October 31, 2022

**Re: Starbucks at 1440 Coors Blvd NW
Erosion and Sediment Control Plan
Engineer's Stamp Date 10/20/2022 (G11E069)**

Based upon the information provided in your submittal received on 10/25/2022, the above referenced ESC Plan cannot be approved until the following comments are addressed.

C101

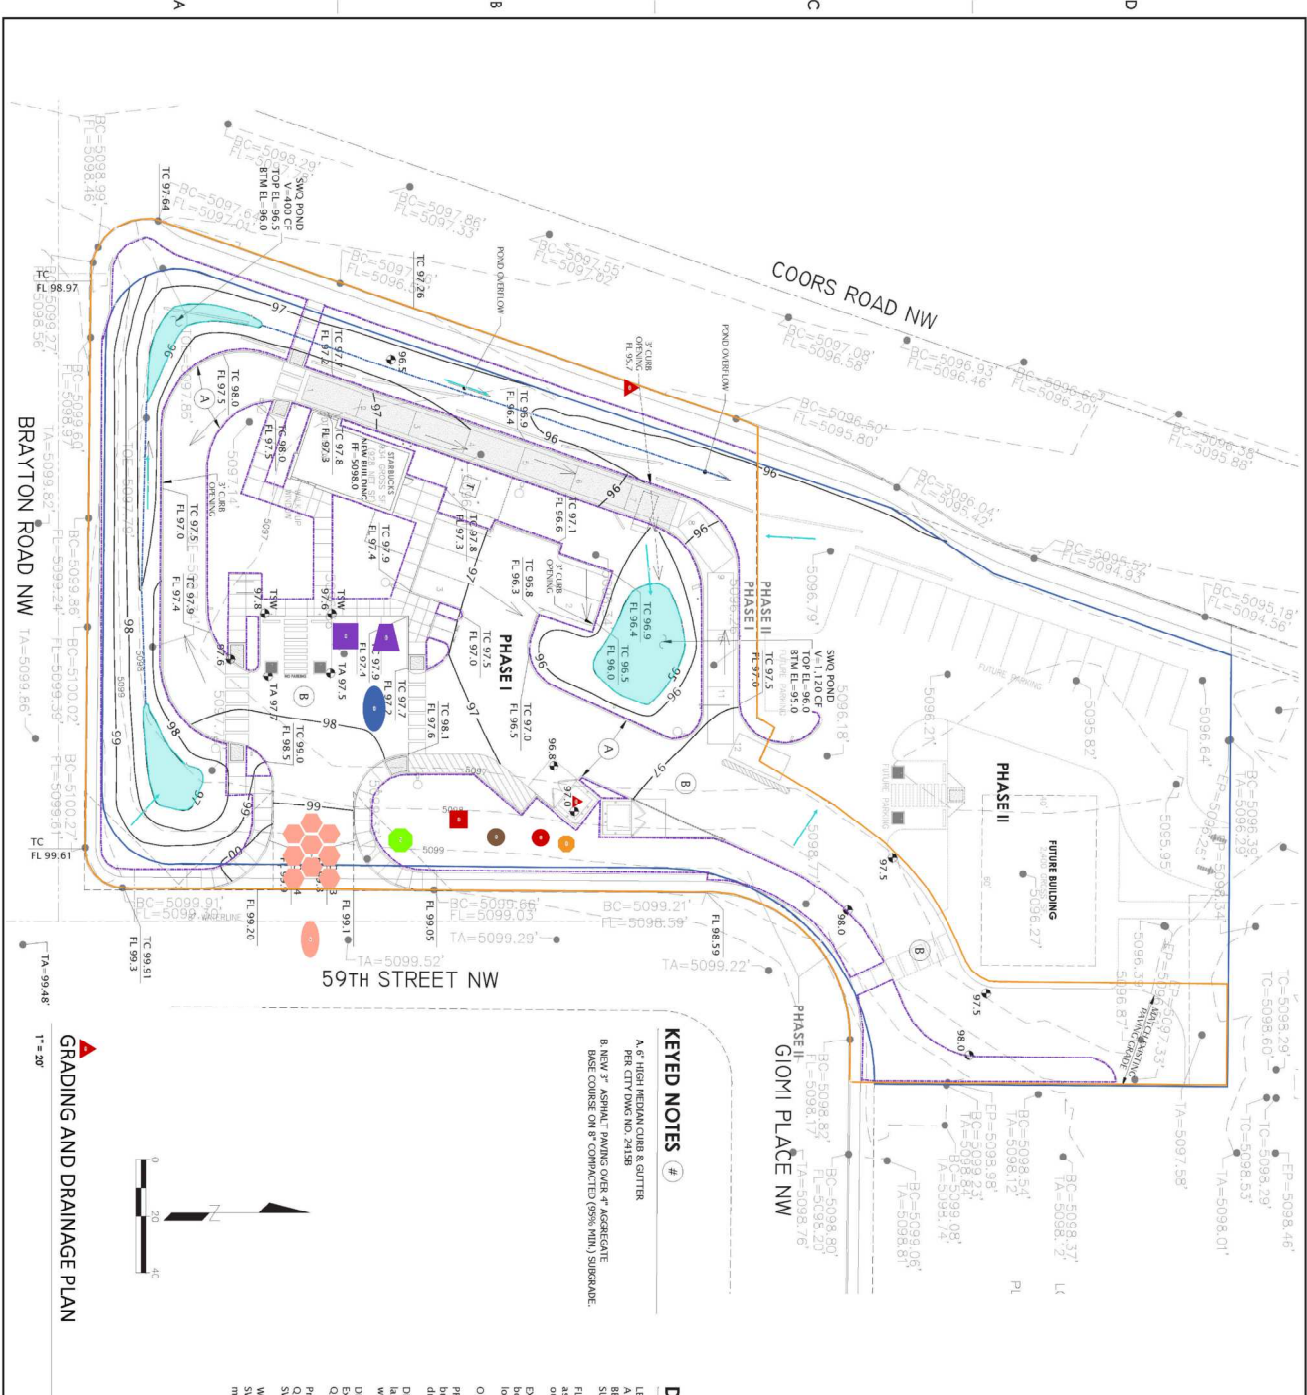
2. The limits of disturbance must include all existing areas of land disturbance. Expand the limits to include Phase 2 since it is already disturbed. (CGP7.2.4.b.i);

4. Cutback swales are generally not applicable for commercial sites. The perimeter controls need to be silt fence all of the way around the disturbed area to control access and prevent sediment from leaving this site on the east and south sides of the site where

5. I can't tell the difference between building, sidewalk, asphalt, and dirt on the ESC Plan. These structures must be clearly identified in the SWPPP per CGP 7.2.4.b.vi. The same information is required in the ESC Application. You may attach a copy of the Site Plan to both the SWPPP and the ESC Application to address this requirement.

7. Provide Engineers certification on all sheets of the ESC Plan especially the map. Update the engineer's stamp date each time the plan is changed.

**PLANTING  
PLAN**

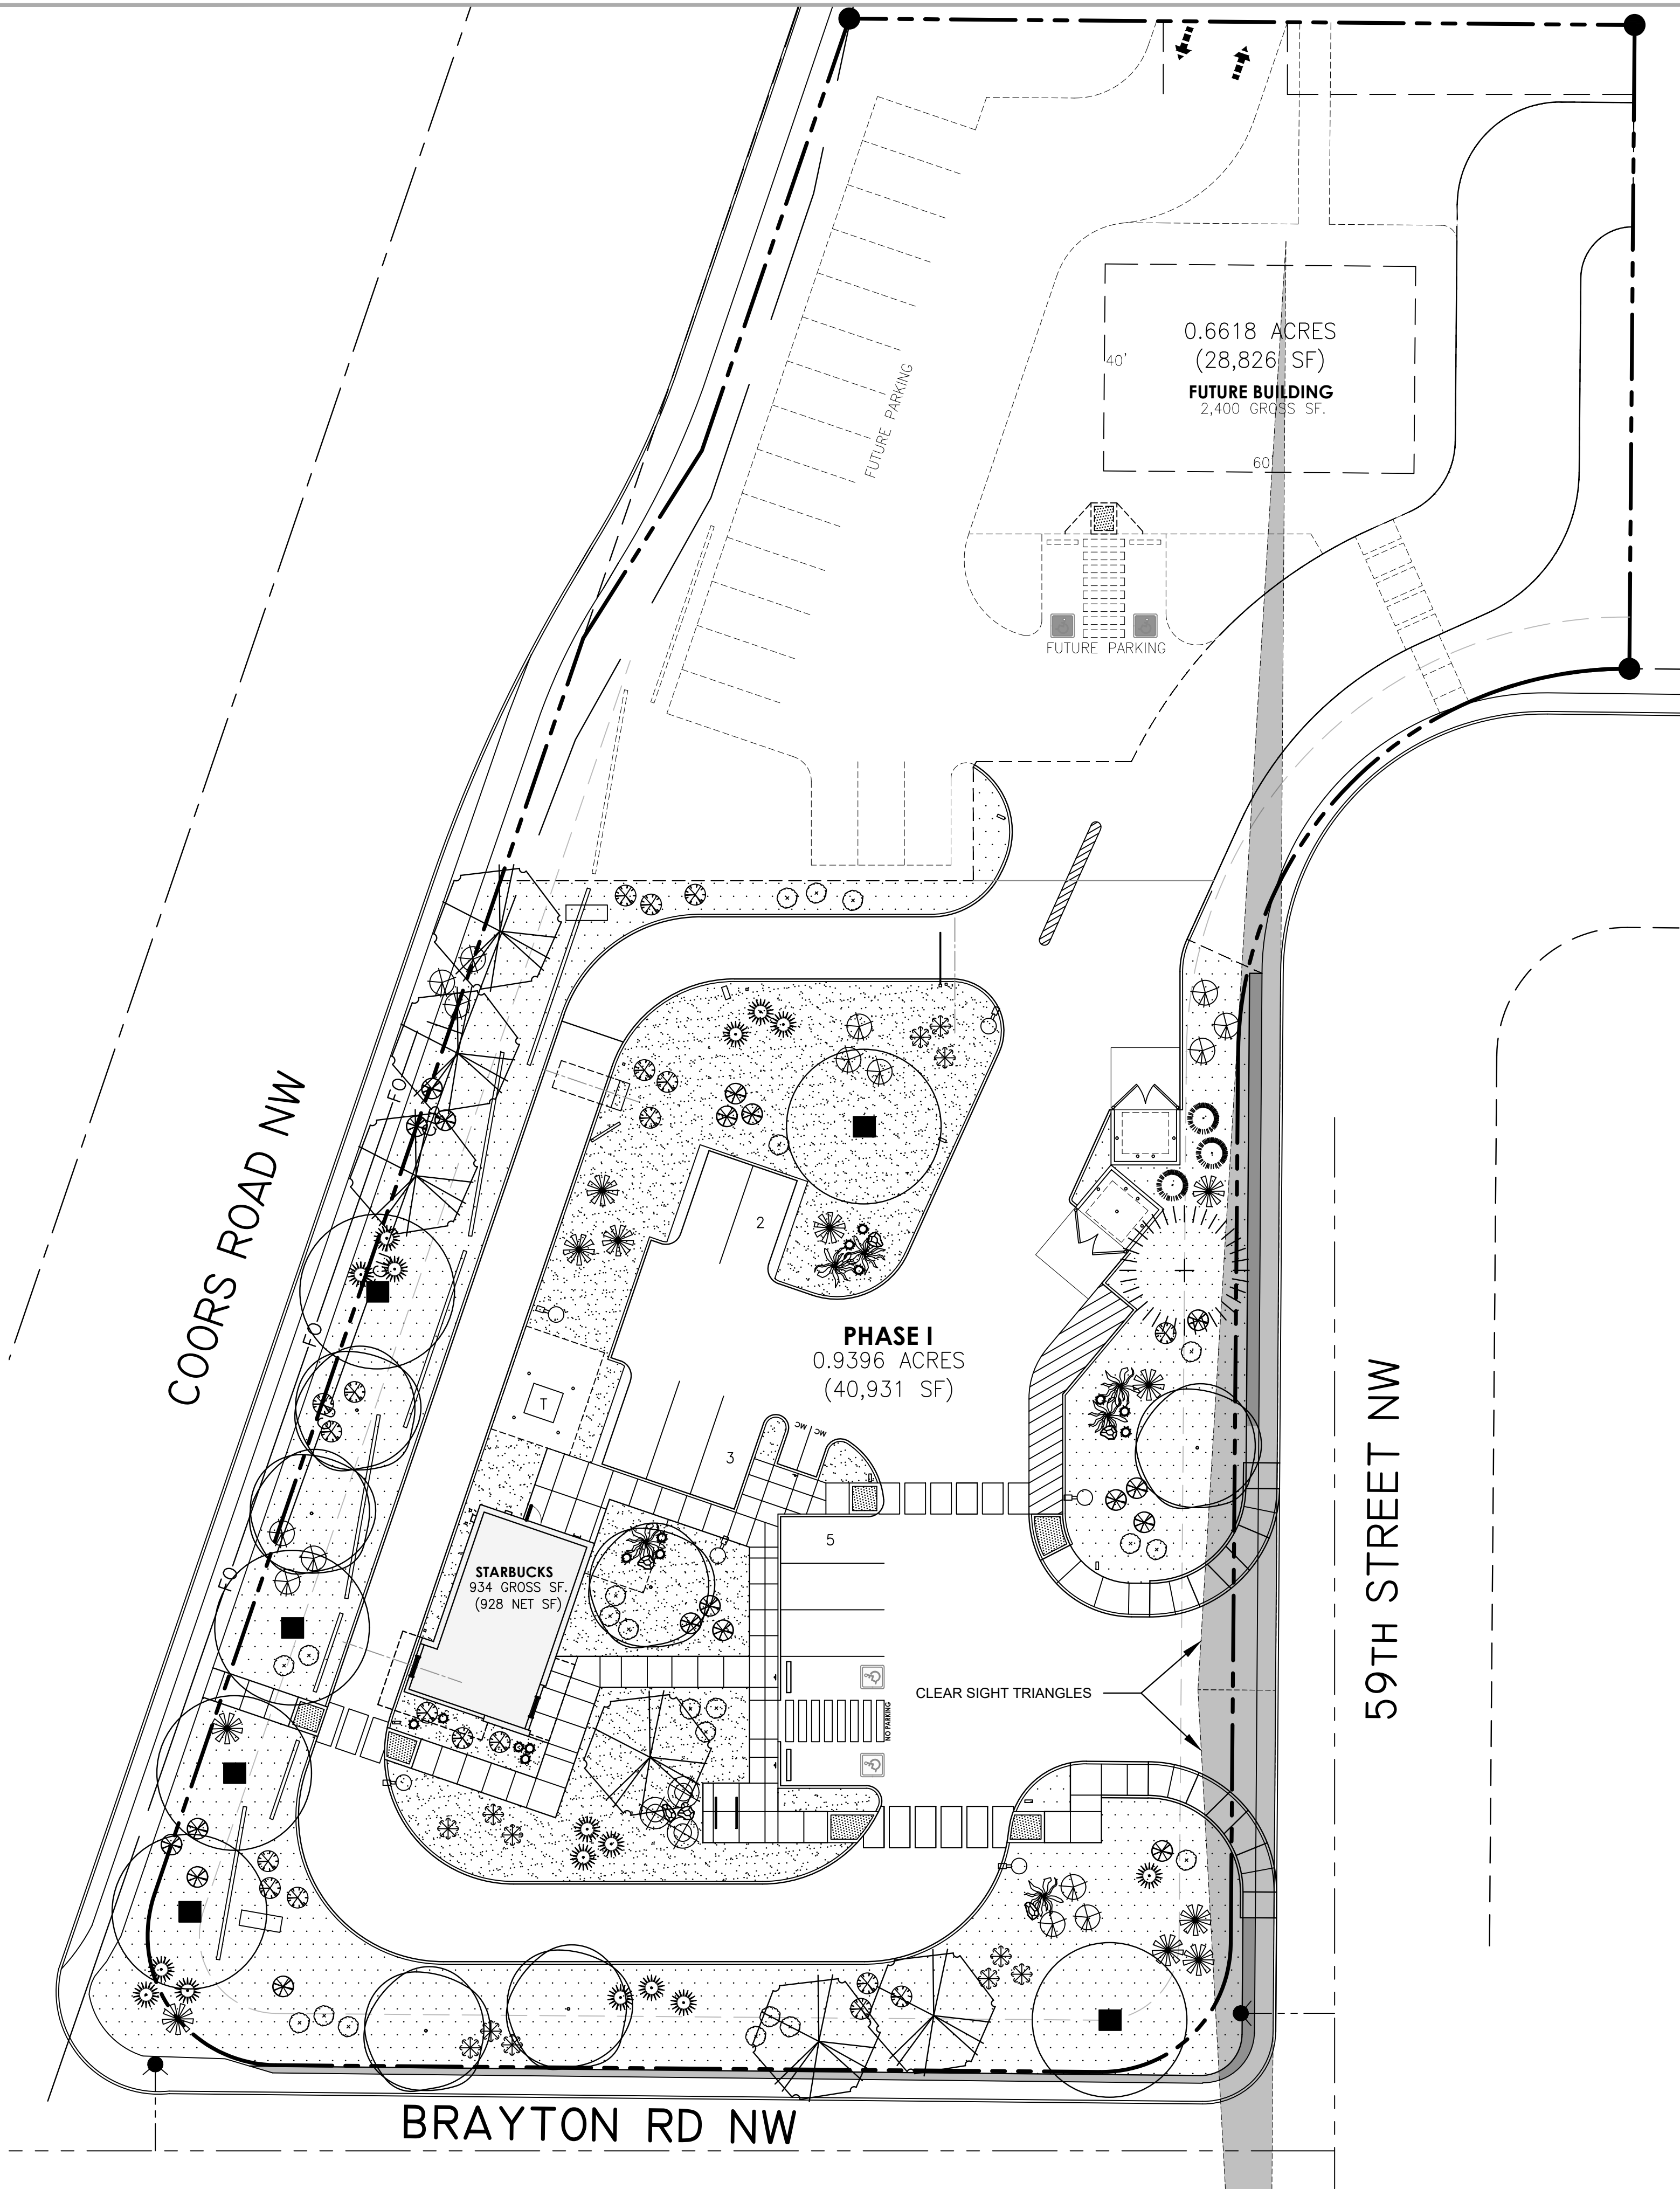
6. The SWPPP must include site-specific interim and permanent stabilization per CGP 9.4.1.c.i. The Landscape Plan can be used to satisfy this requirement and should be submitted separate from the ESC Plan with the application to the Stormwater Quality Section of the Planning Department and it should be included in the SWPPP. Provide a specification on the ESC Plan for any disturbed areas not covered by the Landscape Plan.
